RE: Comment Response Letter – Site Development Plan – Discount Tire - Falcon (File #: PPR2112)

COMMENT RESPONSE LETTER

Site Development Plan

D-4

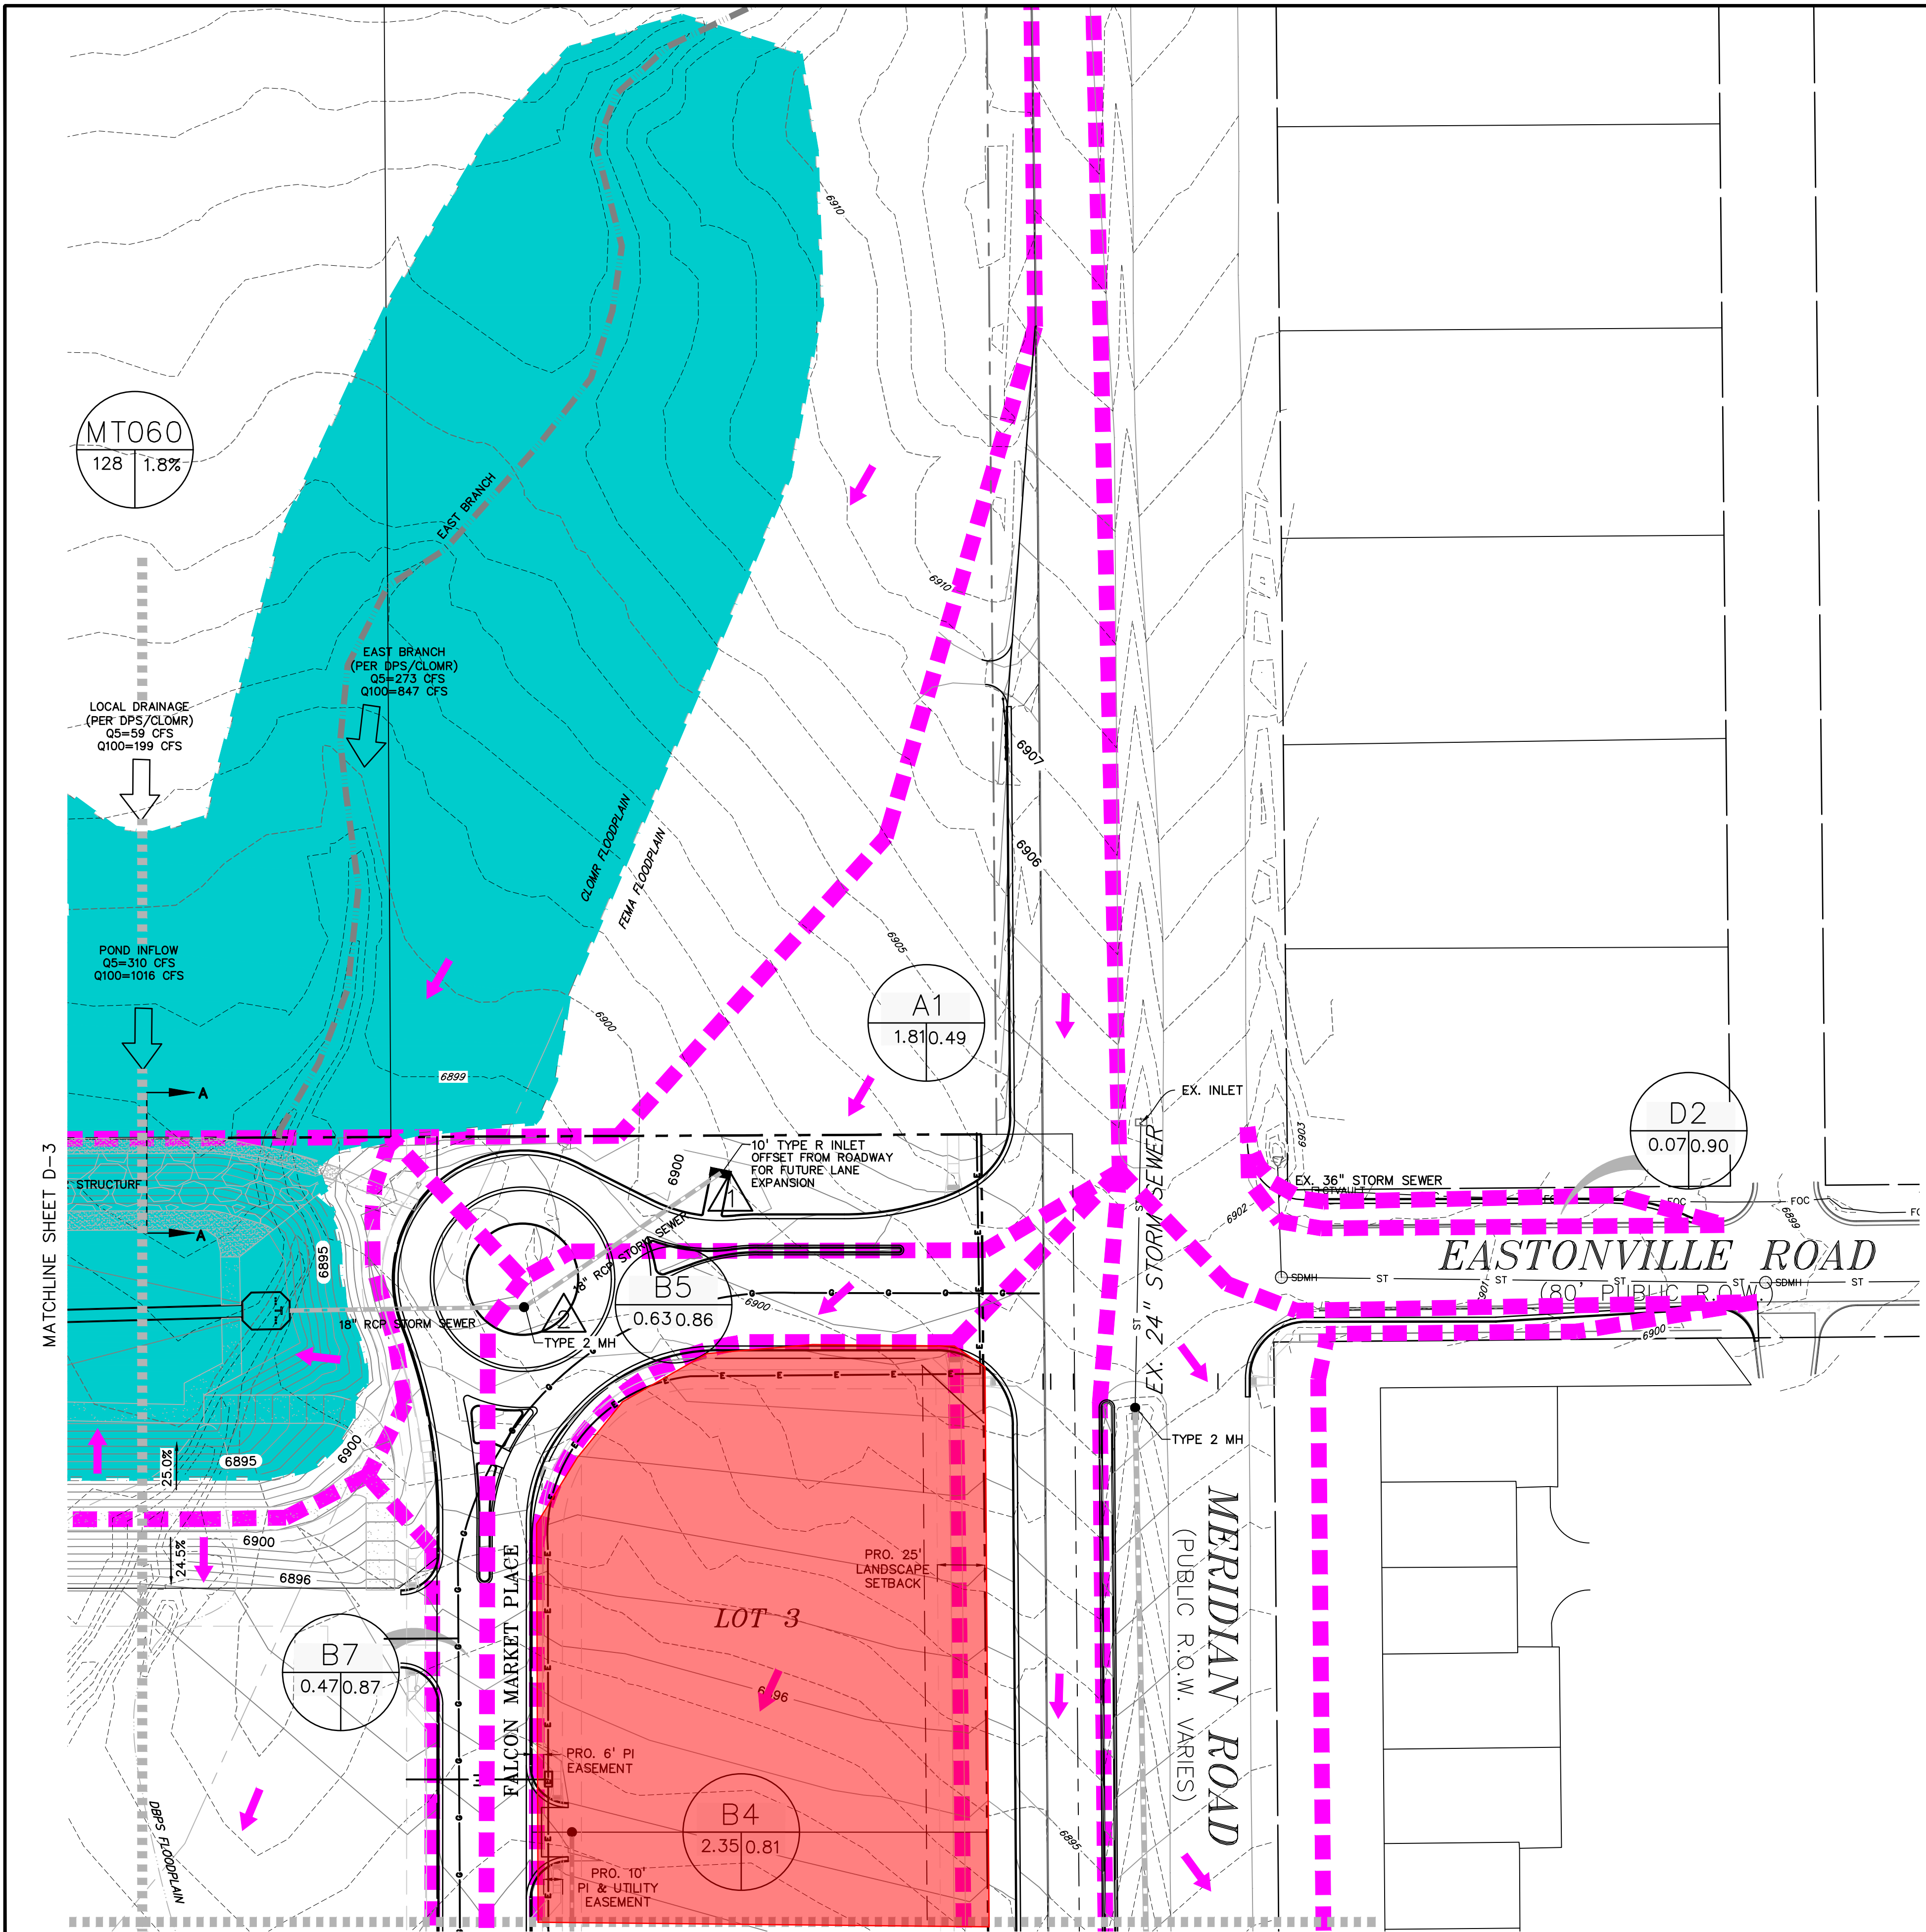
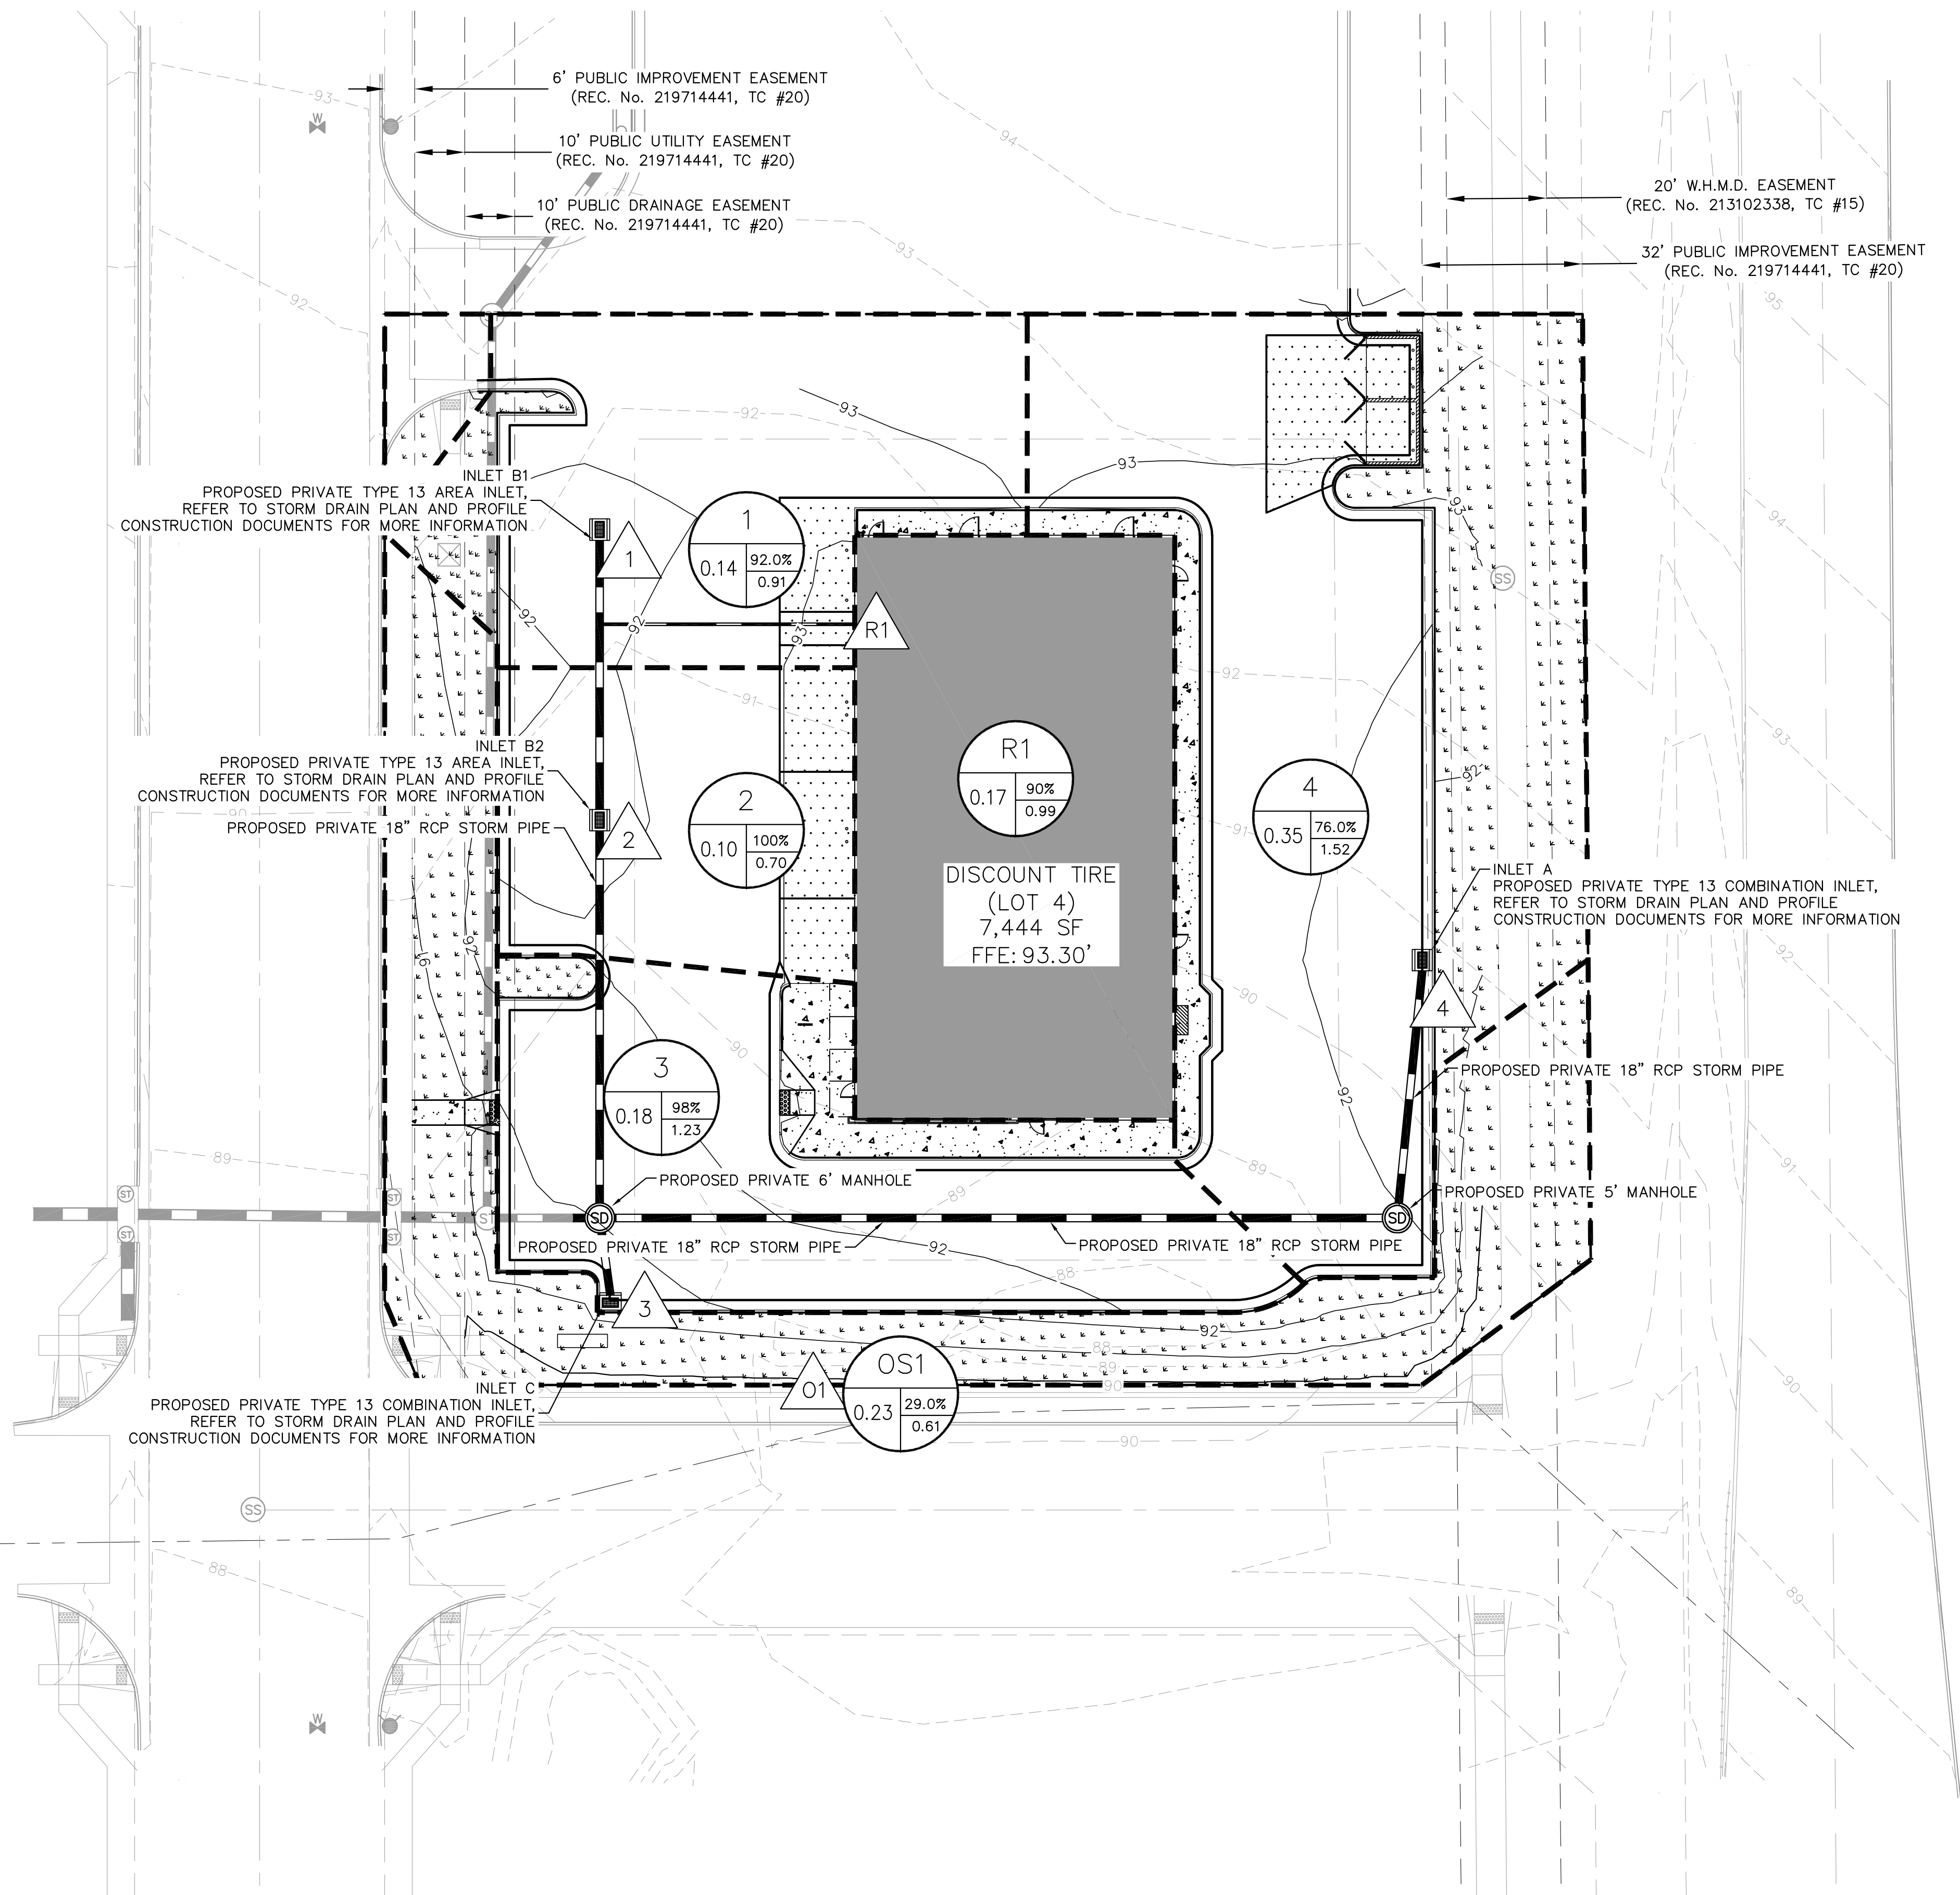
- *Response: The storm profiles have been updated with 5 and 100 year flows.*
- 15. The drainage plan indicates one 5ft and one 6ft manhole. Revise accordingly

- *Response: A 6FT manhole has been added to the EOPCC in appendix E.*
- 16. Please provide contour labels throughout your drainage plan
 - *Response: Contour labels have been added to the proposed and existing surfaces.*

19. Please provide a basin and design point summary table showing the flows of each of the basins and design points.

20. Revise to OS1, to match text on page 7 of FDR

- *Response: A summary table has been added to the proposed drainage map.*

- *Response: Revised, thank you!*
